## KITTITAS COUNTY COMMUNITY DEVELOPMENT SERVICES

**Subject: Shoreline Exemption Permit (SX-25-00010 Gott) – Deemed Incomplete – Request for Additional Information**

Kittitas County Community Development Services (CDS) received your Shoreline Exemption Permit application (SX-25-00010 Gott) on July 23, 2025 for 531 Ermine Loop (Parcel 300534). Staff has reviewed your application and determined that more information is needed before this application can be processed any further. As such, Kittitas County declares your application **incomplete** as of August 5, 2025.

SCALE: ONE BOX = 10 FEET

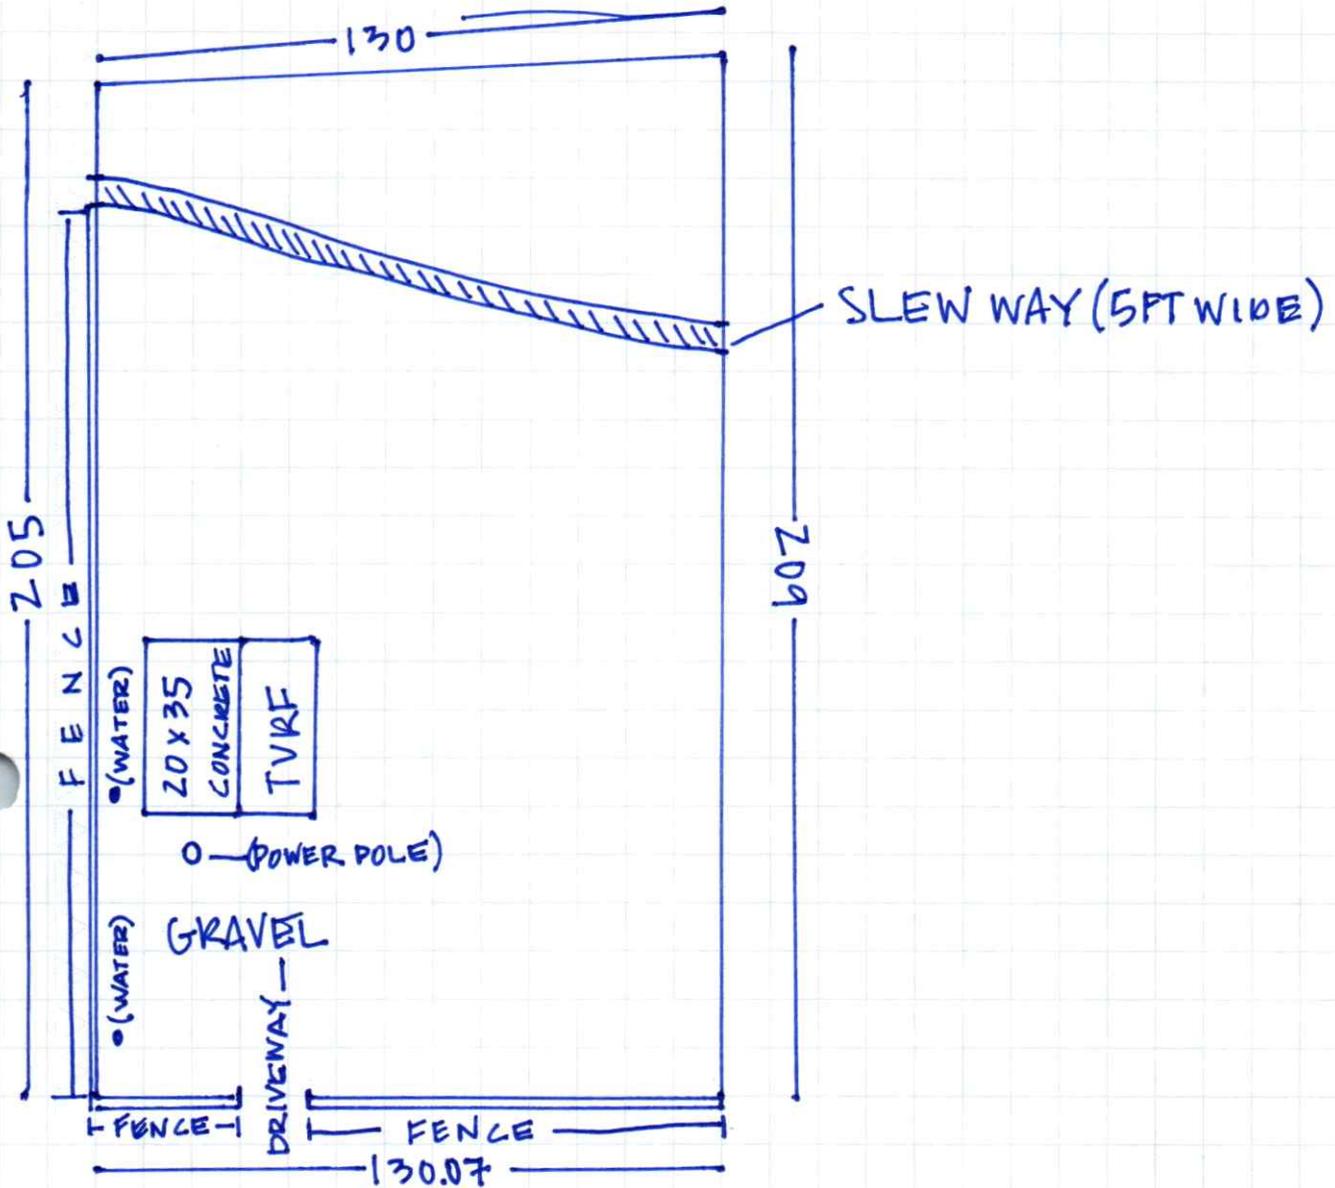
1. Please provide an updated site plan showing the exact location of all proposed structures, septic system components, drainfields, etc. In addition, please provide their dimensions, as well as each component's distances from property lines, rivers, and horizontal distances from the Ordinary High Water Mark (OHWM).
2. Please provide an updated narrative explaining all aspects of the project.
